Ribble Valley Borough Council
Housing & Development Control

Application no: **3/2023/0605**

Address: **Mill Race Cottage White Carr Lane Dilworth Bottoms Ribchester PR3 3ZB**

Proposal: **Replacement dwelling with detached garage including the demolition of an existing agricultural-style building. Resubmission of 3/2022/1061.**

Proposed Site Plan

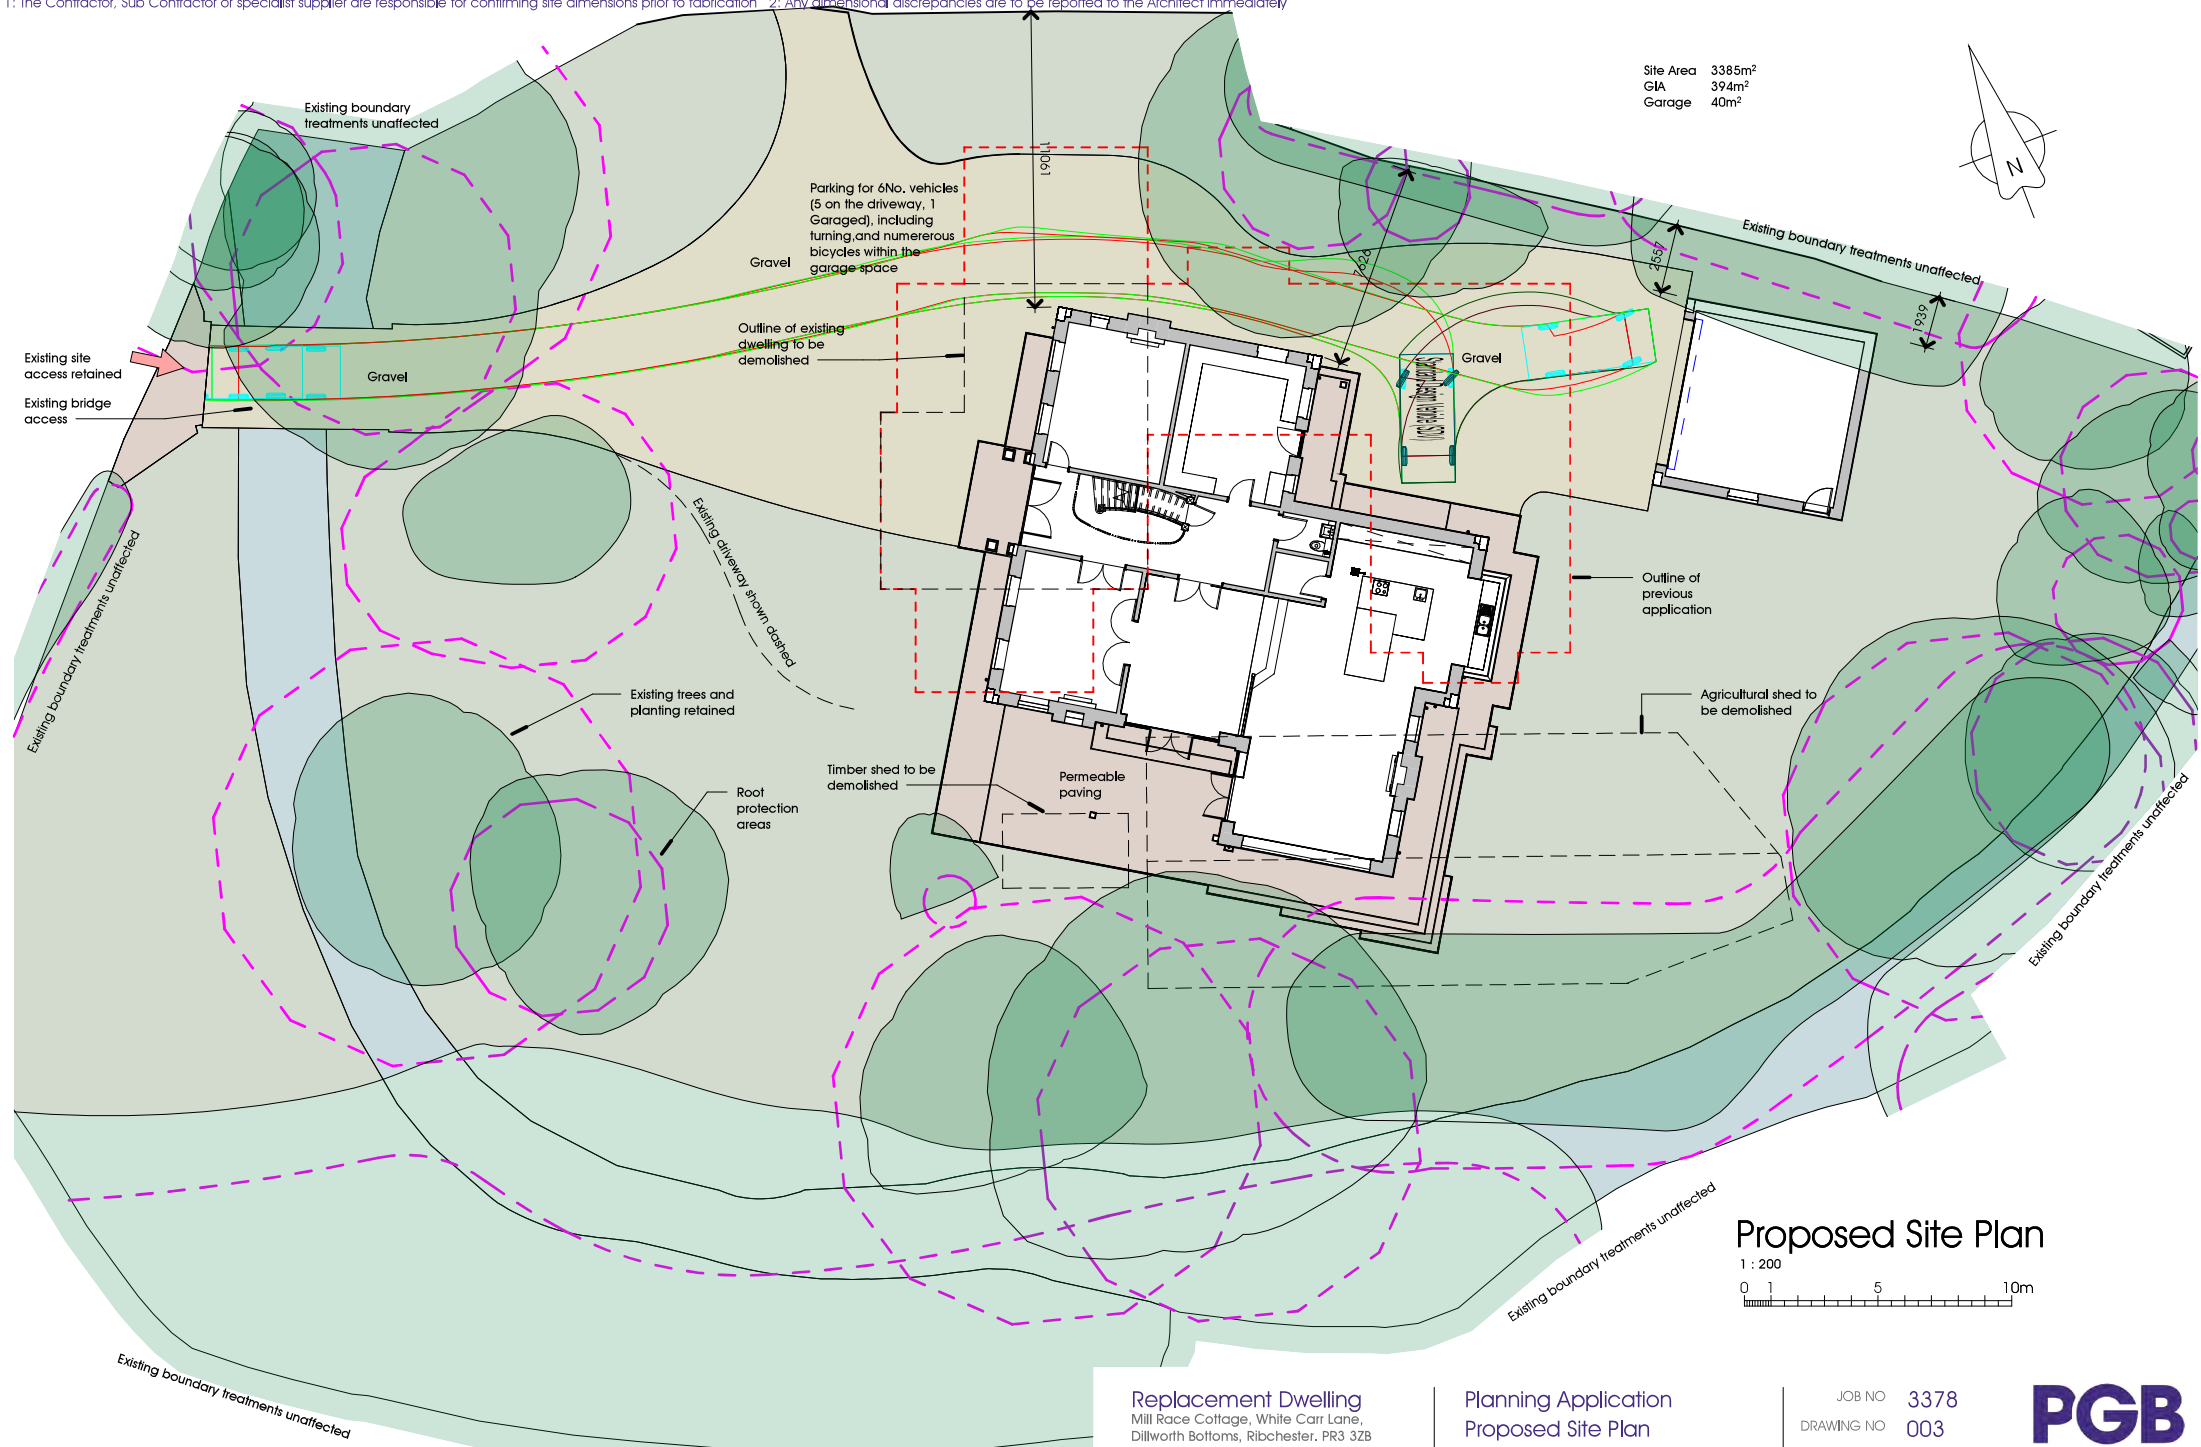
The LHA have reviewed PGB drawing number 003 titled "Proposed Site Plan" and are aware that the site access will remain unaltered following the proposal. Therefore, the LHA have no further comments to make regarding the access.

The LHA have reviewed PGB drawing number 003 titled "Proposed Site Plan" and are aware that the dwelling complies with the LHAs parking standards as defined in the Joint Lancashire Structure Plan. Therefore, the LHA have no objection to the proposal.

2. The development hereby permitted shall not be occupied until such time as the parking and turning facilities have been implemented in accordance with PGB drawing number 003. Thereafter the onsite parking provision shall be so maintained in perpetuity.
